Re: Planning Application 18/0992

Address: New Fold Garage Neville Street Longridge PR3 3FD

Description: Proposed additional valeting service to an existing garage operation and erection of 1.7m high Perspex panel screen.

Simon Hardie
Highways Development Control
Lancashire County Council

**BLOCK PLAN**  
 1:500

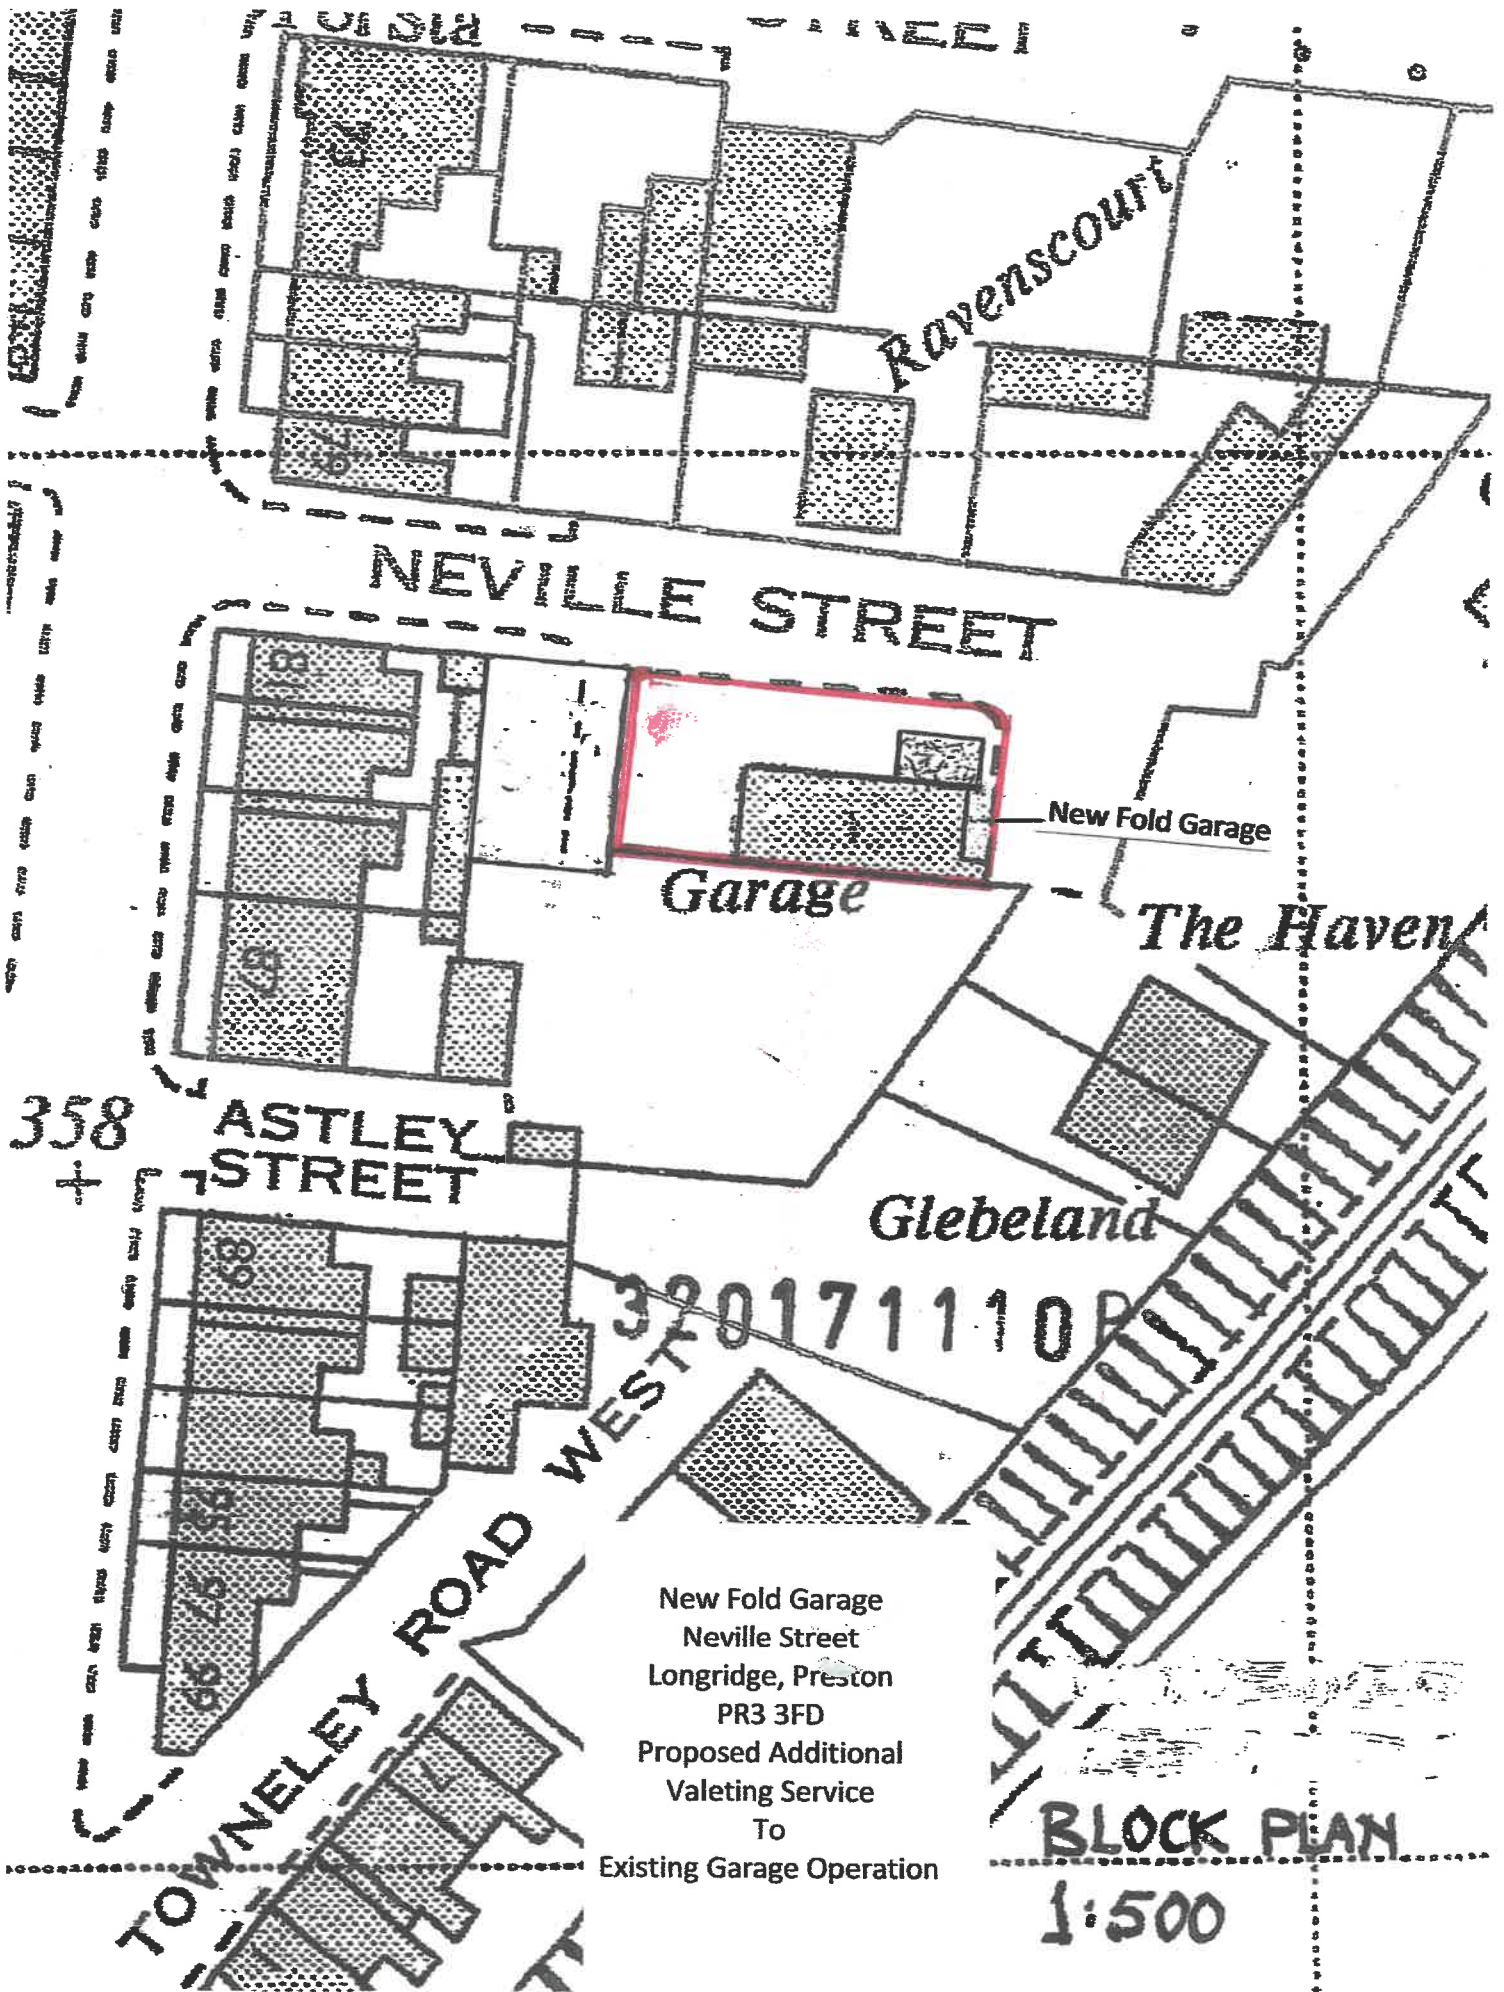
There is a discrepancy between the description of the proposal on the application form and the information supplied on the latest drawings supplied. The application makes reference to the valeting being an additional service to the existing garage services, whilst the drawing supplied makes reference to the valeting service being the main usage of the site as the former workshop bay are labelled as Valeting areas.

It is noted that any vehicles waiting to be washed are expected to wait on the highway outside the residential premises, the proposed direction of travel could lead to a conflict of movement, as drivers dropping off cars for pre booked valets are likely to simply park and leave the vehicle entering through the exit rather than wait in the queue. A reversal of the direction of travel would be preferable.

A condition requiring the business to function on an appointment only operation and any promotional signage and advertising should reference the need to book an appointment.
